## Appeal Decision

**Appeal Ref: APP/R5510/W/25/3366074**

**81 Bedwell Gardens, Hayes, Hillingdon UB3 4EE**

DRAWING TITLE
PROPOSED SIDE
ELEVATIONS

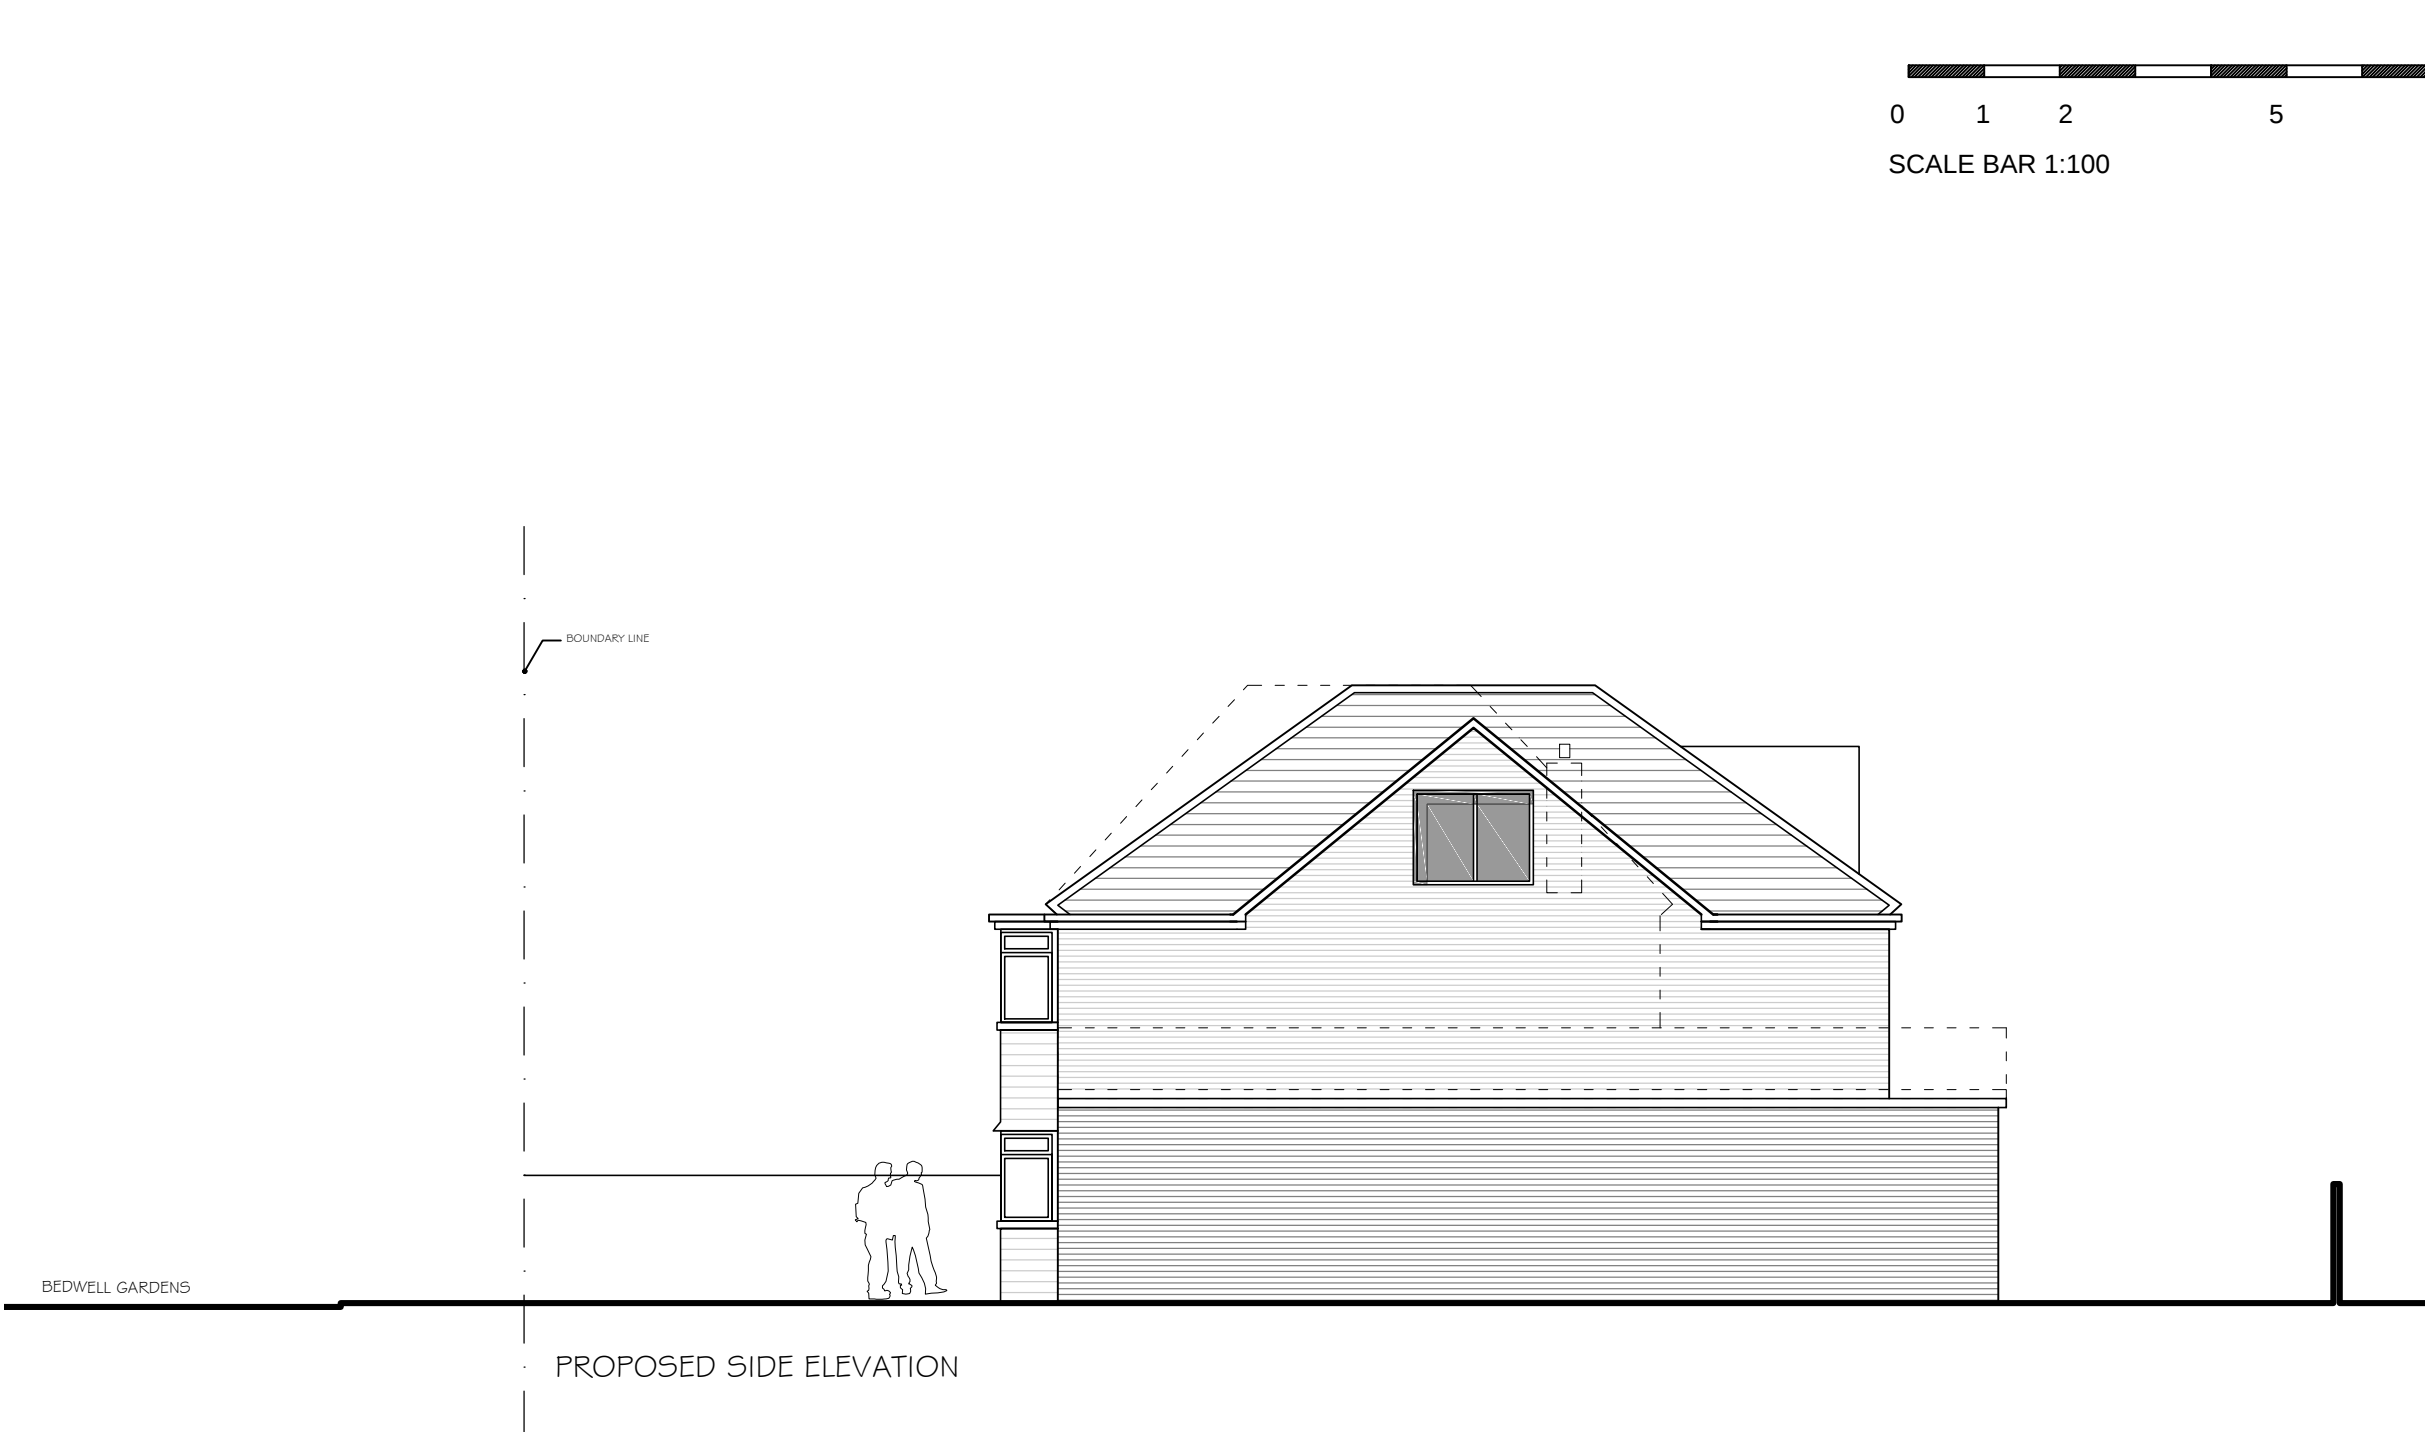
7. Policy DMHD1 of the LPP2<sup>1</sup> requires, among other things, that roof extensions should be subservient to the scale of the existing building. The proposed roof would extend unrelieved across the entirety of the property including across the side extension. The characteristic small hipped feature above the front bay would also be lost. As such the proposed roof would not appear subservient to the existing building, in conflict with the policy, and would cause a dilution of the original character of the property. The proposal would not therefore comply with Policy DMHD1 when read as a whole.
